Recommendation Report for Planning Permission for Works or Extension to a Dwelling

REF NO: **AW/236/13/**

LOCATION: 37 Lincoln Avenue
 Bognor Regis

PROPOSAL: Replacement single storey rear extension. Resubmission of AW/156/13. This application also lies within the parish of Pagham

DRAWN BY	REVIEWED BY
SJ	SJ
DRAWING NUMBER	4C

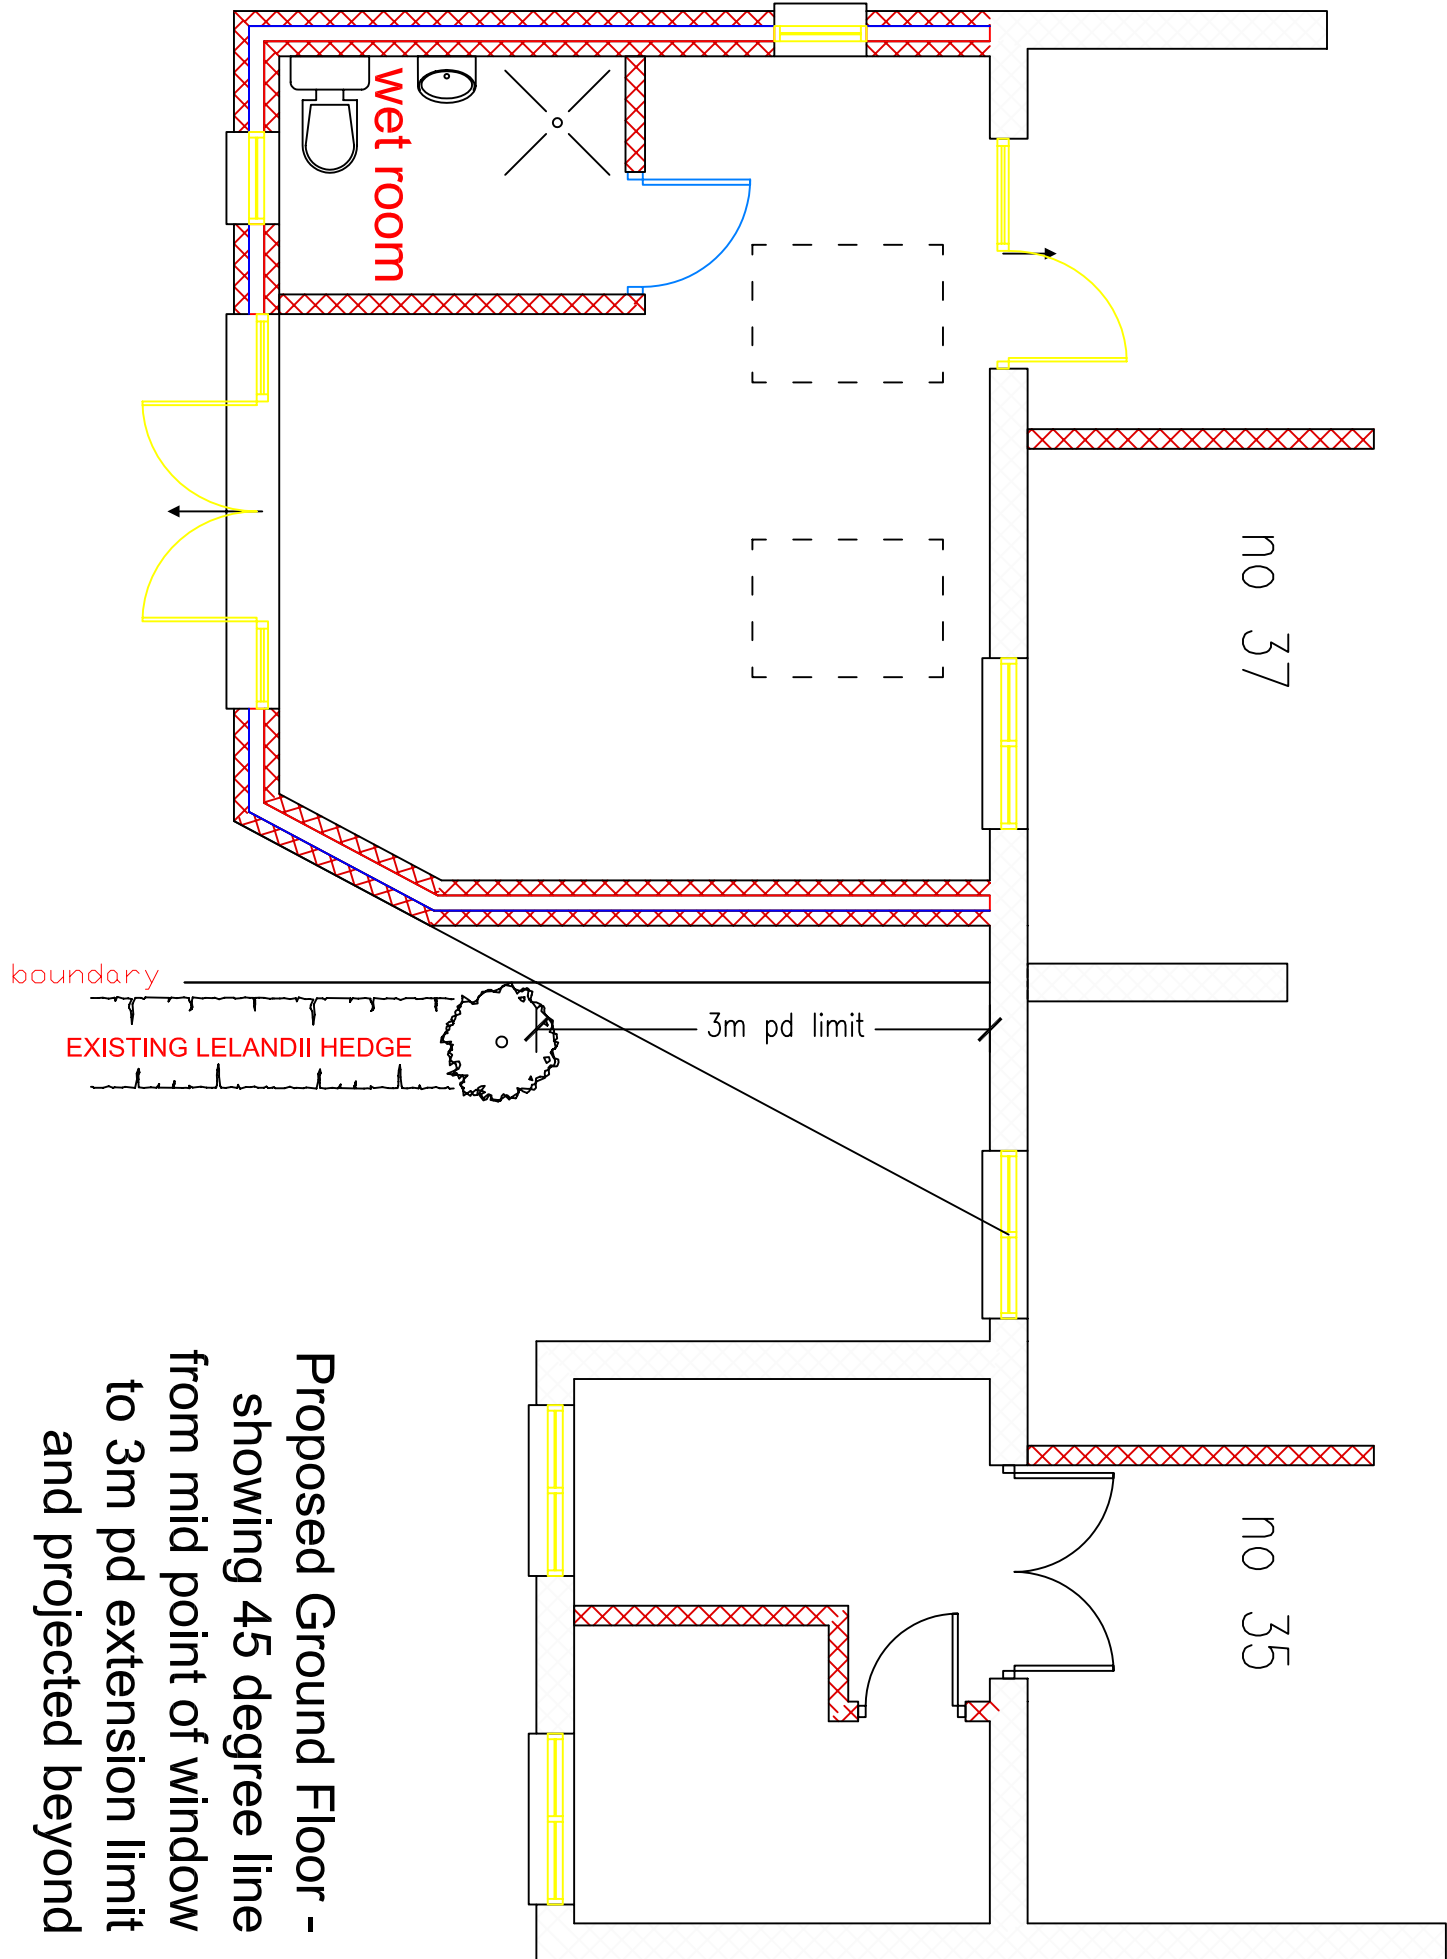
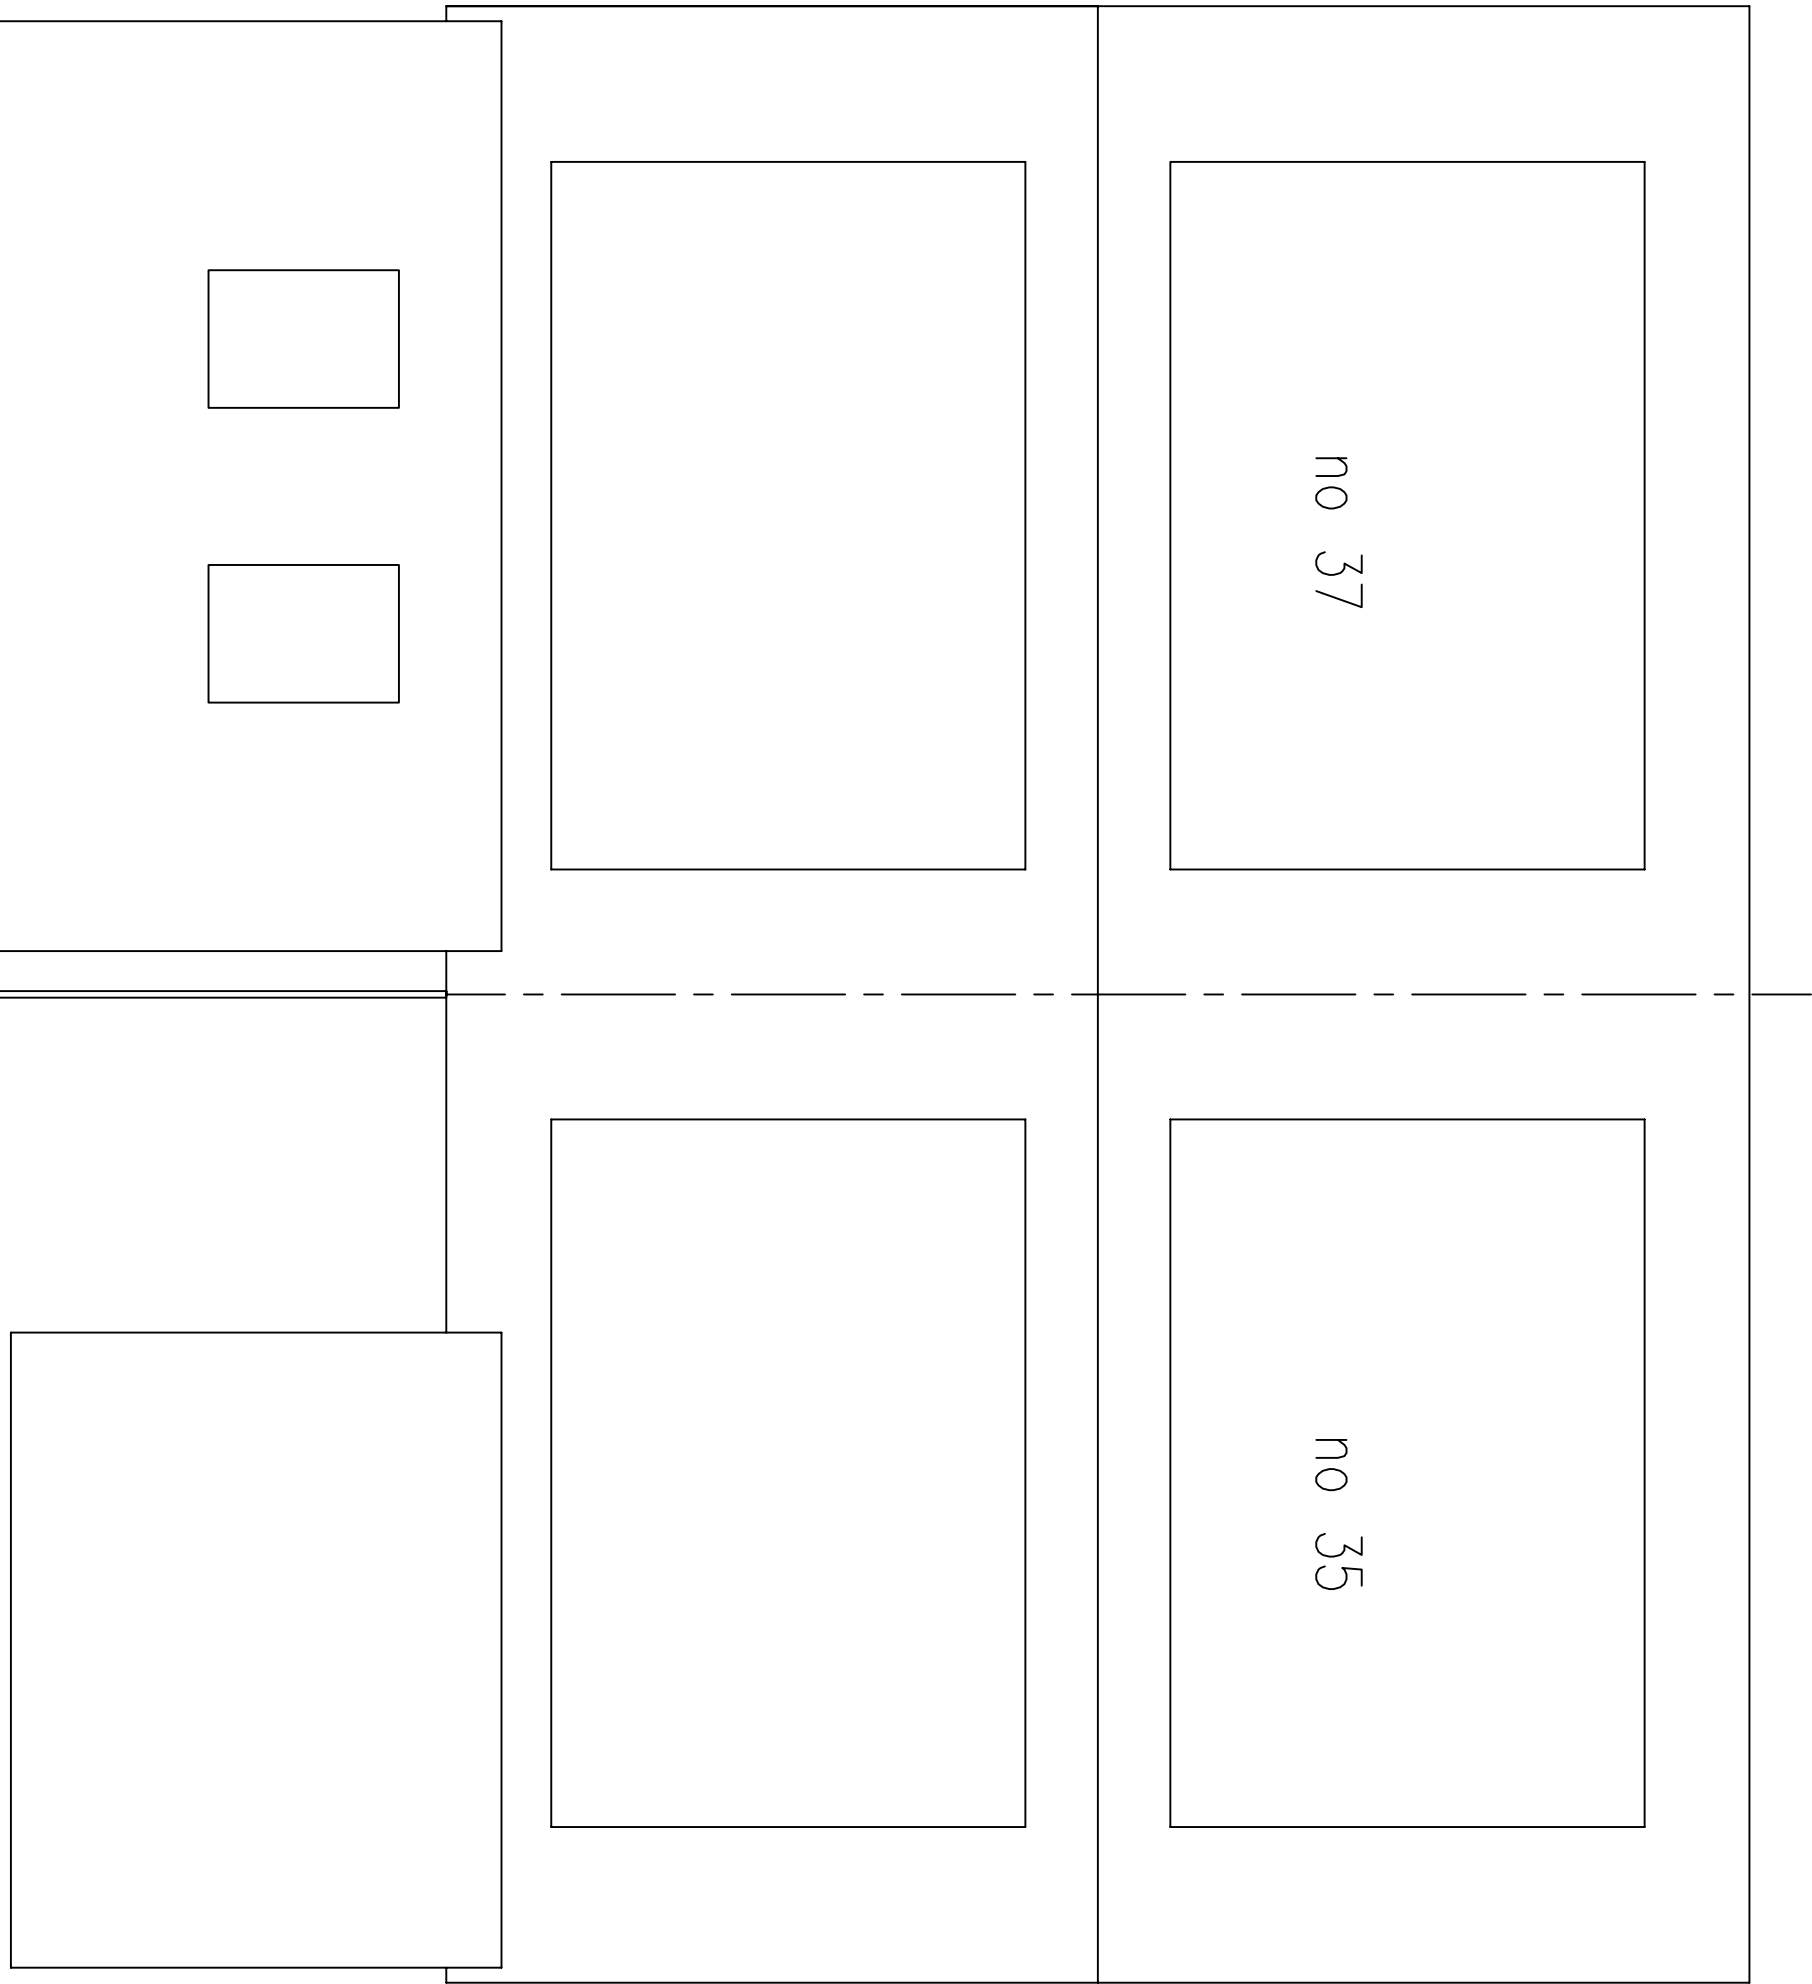
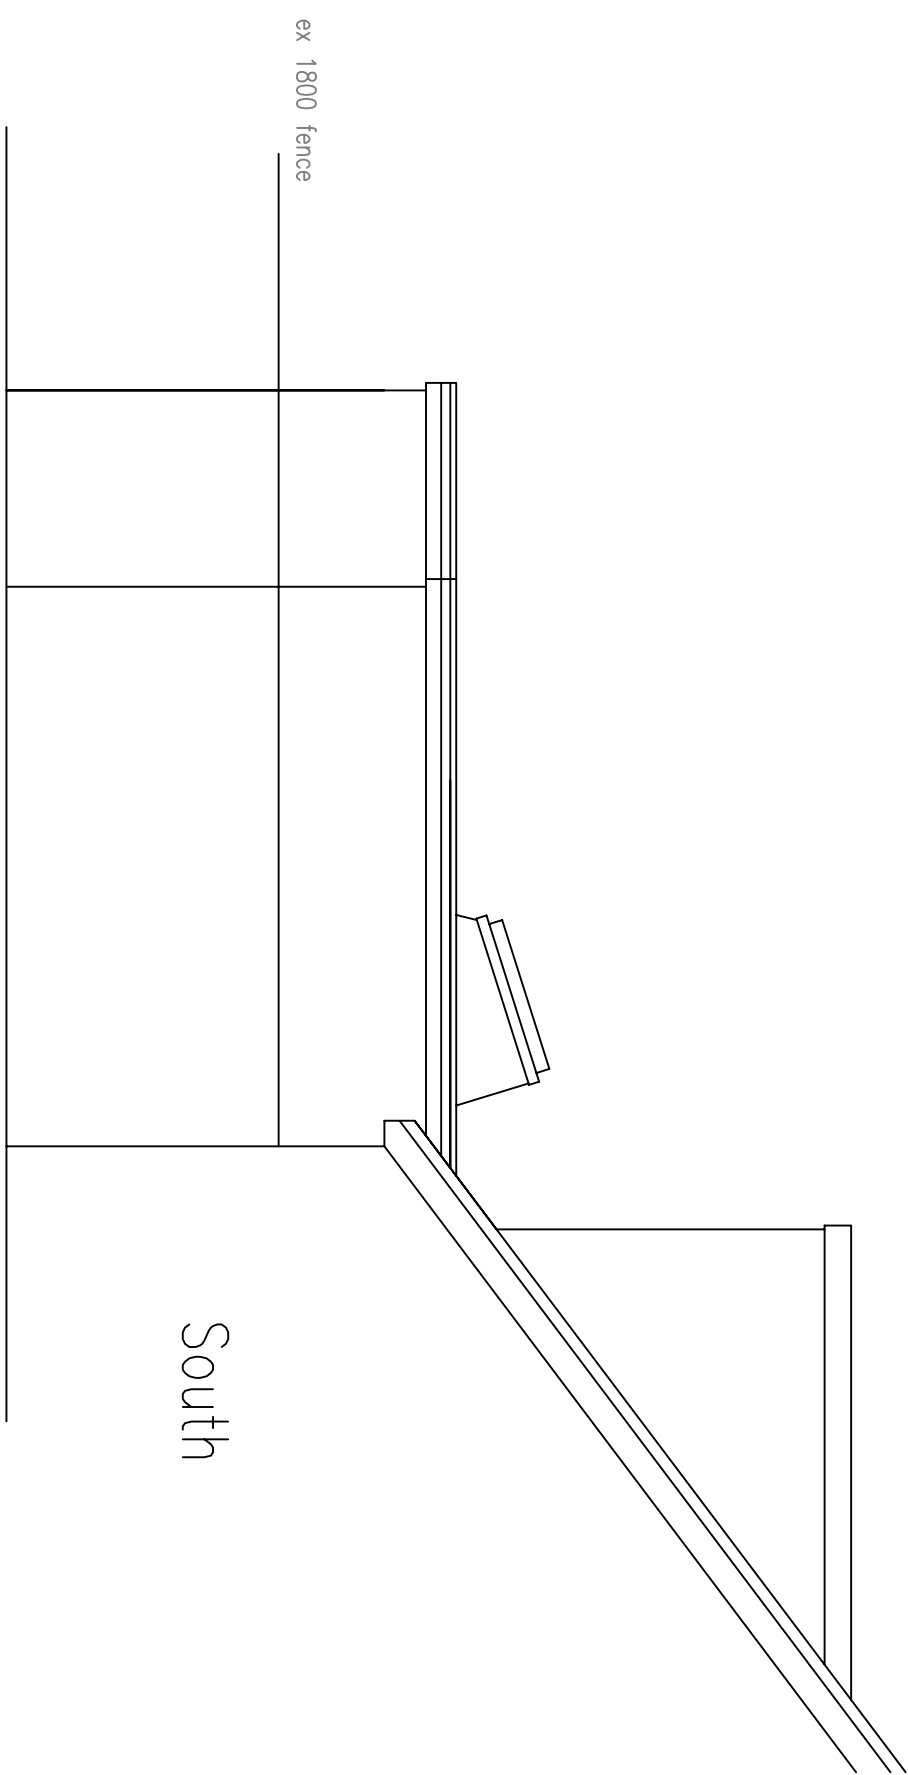
Notwithstanding the regulatory justification submitted by the applicants agent, concern was expressed at the partial cloaking of the fenestration of the adjacent property by the bulk and length of the proposed extension. Whilst acknowledging the design dilemma of seeking to secure the desired improvement in accommodation within the constraint of a narrow plot, members resolved, on balance, to register objection on the basis of prejudice to the amenity and quiet enjoyment of the adjacent dwelling.

The application for a single storey rear extension is a re-submission of a previously refused rear extension AW/156/13. The previous application was refused on the basis that the rear extension by reason of its rear projection would be detrimental to the residential amenities of the occupiers of the neighbouring property No 35. By reason of its rear projection it was in conflict with the 45

degree rule when measured from the middle point of the bedroom window on the neighbouring property No 35.

The revised plans now show that the rear extension being of the same width and height will be set in slightly from the side boundary with No 35 by approximately 0.3m. The rear projection at this point adjacent to No 35 is 3.6m then extending to a depth of 4.9m. In view of this revision it now complies with the 45 degree line when measured from the mid point of the neighbouring bedroom window. The southern side boundary has fencing approximately 1.8m in height and it is noted that the neighbouring property No 35 has planted hedging behind this fencing which is slightly higher than the fencing. An extension not exceeding 3m in depth and 3m in height could be constructed in this location without the need for the submission of a formal planning application. The rear projection of the extension at this point with No 35 is 3.6m and whilst it is noted that the extension may be visible above the boundary fencing by approximately 1.1m it is not considered that this would create a loss of outlook or unacceptable overshadowing to recommend refusal.
